From: Simon Davis
Sent: 16 September 2019 11:27
To: 'Daniel O'Shea (Drew Smith)' [REDACTED]
Cc: Adrian Barker [REDACTED]
Subject: RE: Planning Consultation on: P/70/19/RES

Separately, I have received the attached comments of Pagham Parish Council. I comment on their advice as follows:

HOUSE TYPE - C [Semie-Detached v2]
Plot numbers: 16, 17, 18, 19, 34, 35, 36, 37

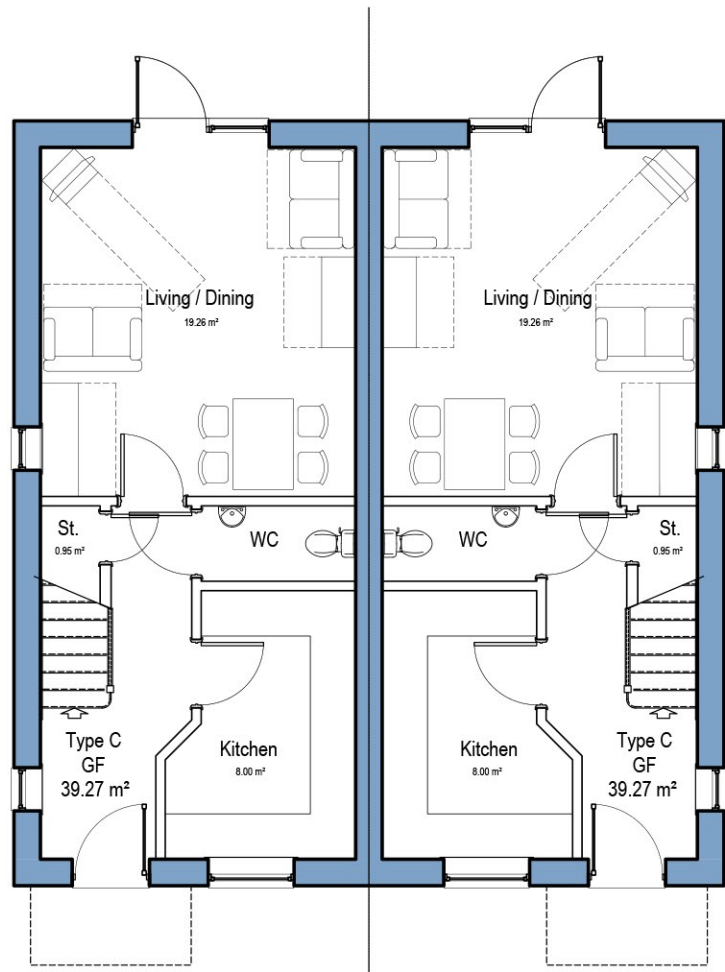
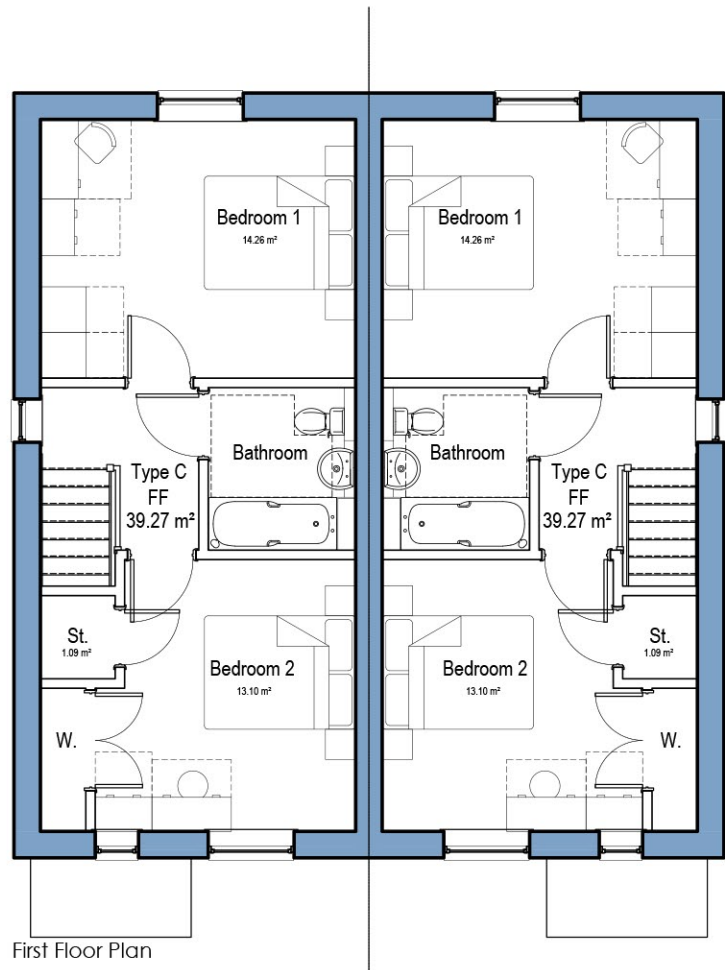
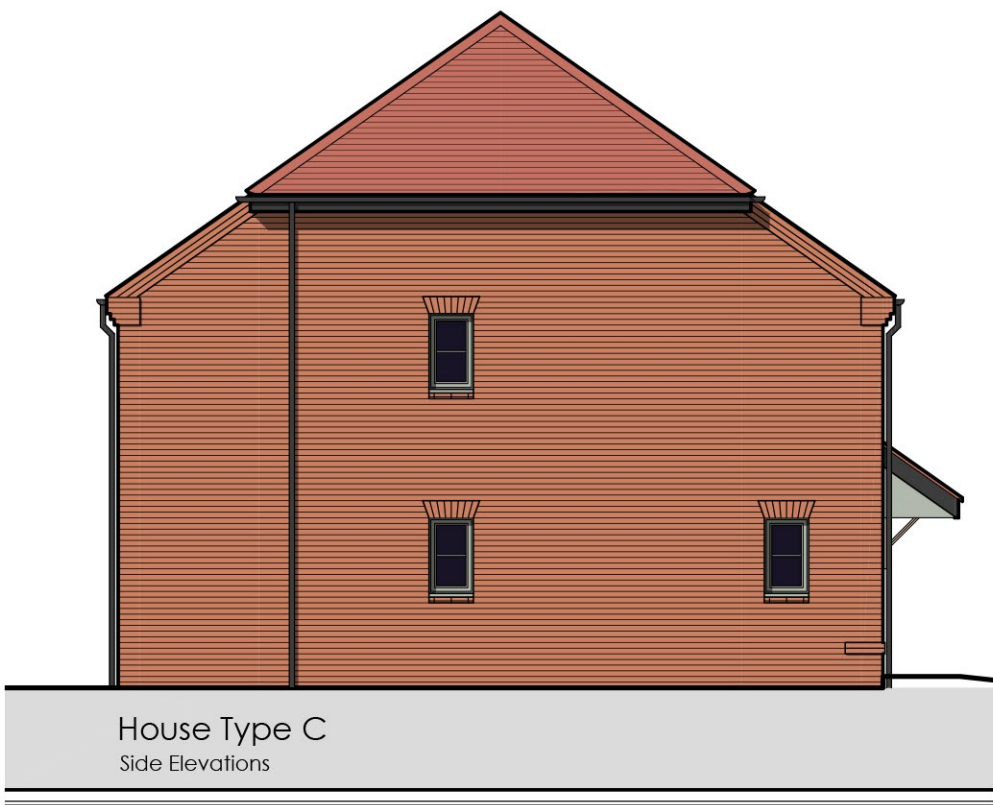
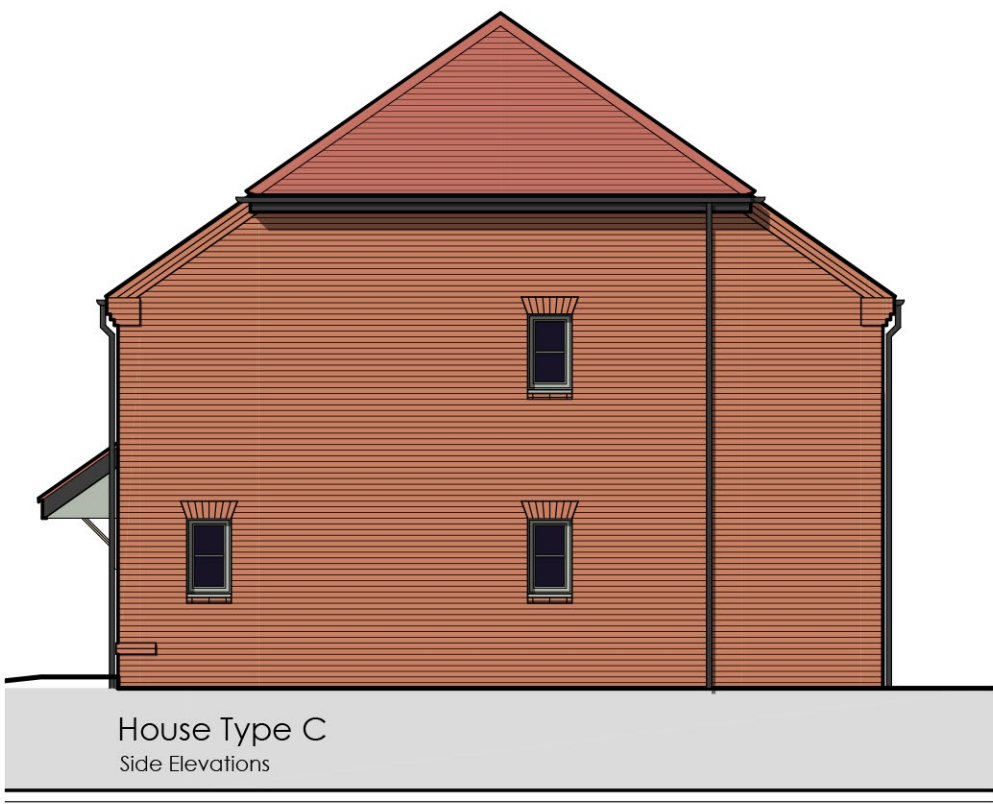
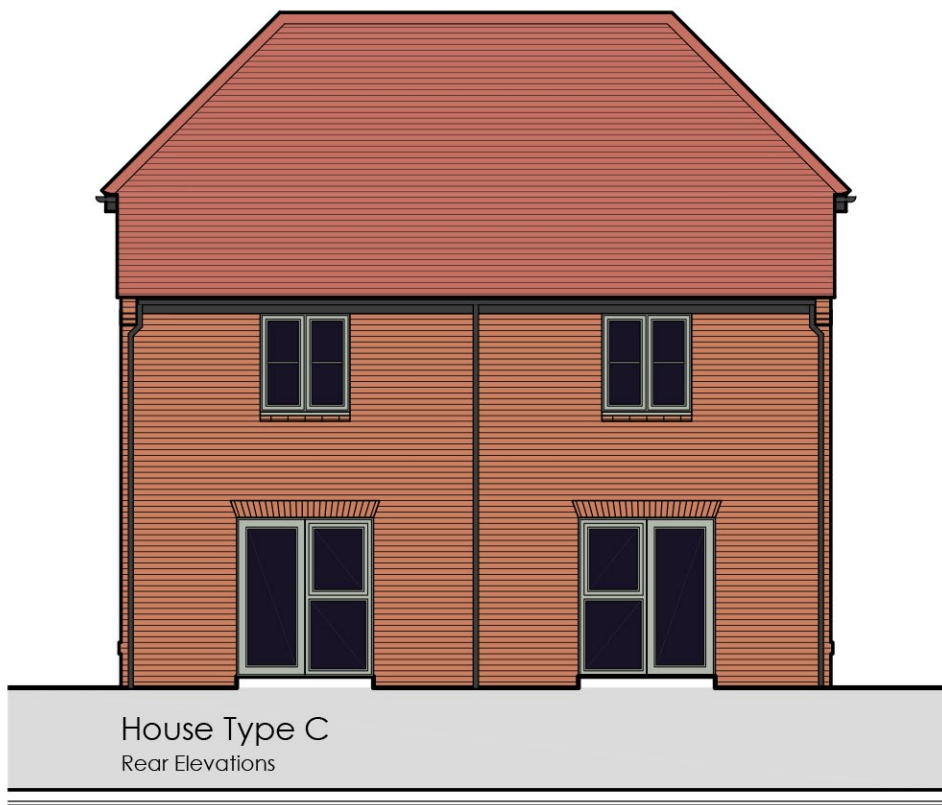
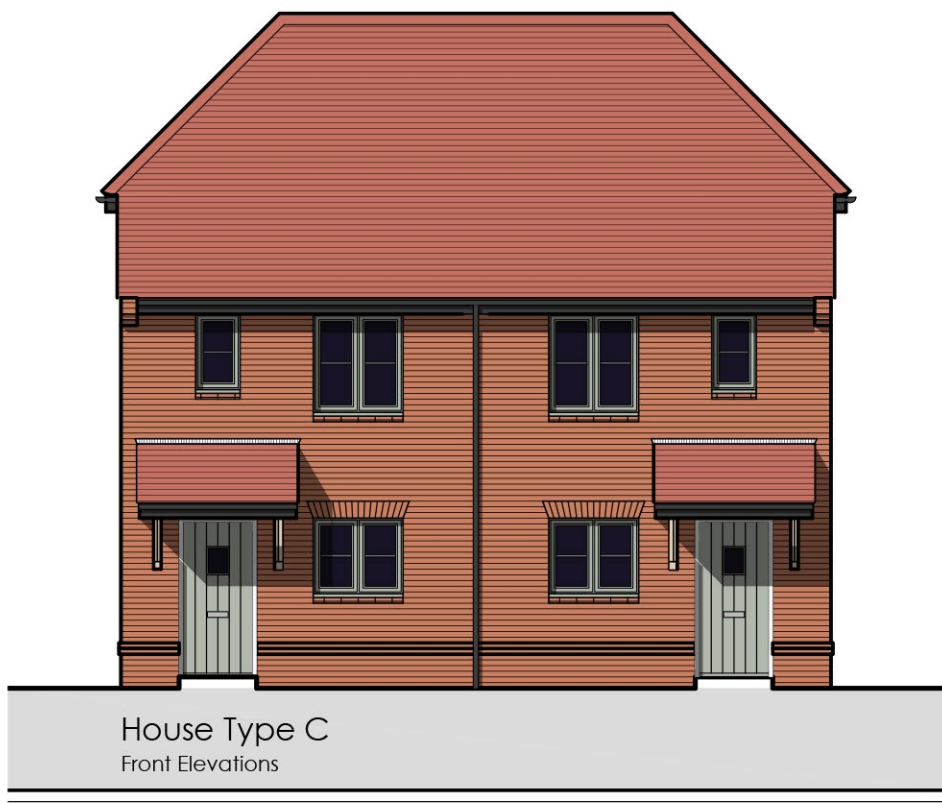
Plots 34/35 & 36/37: I agree that this is an unacceptable relationship to these existing houses.
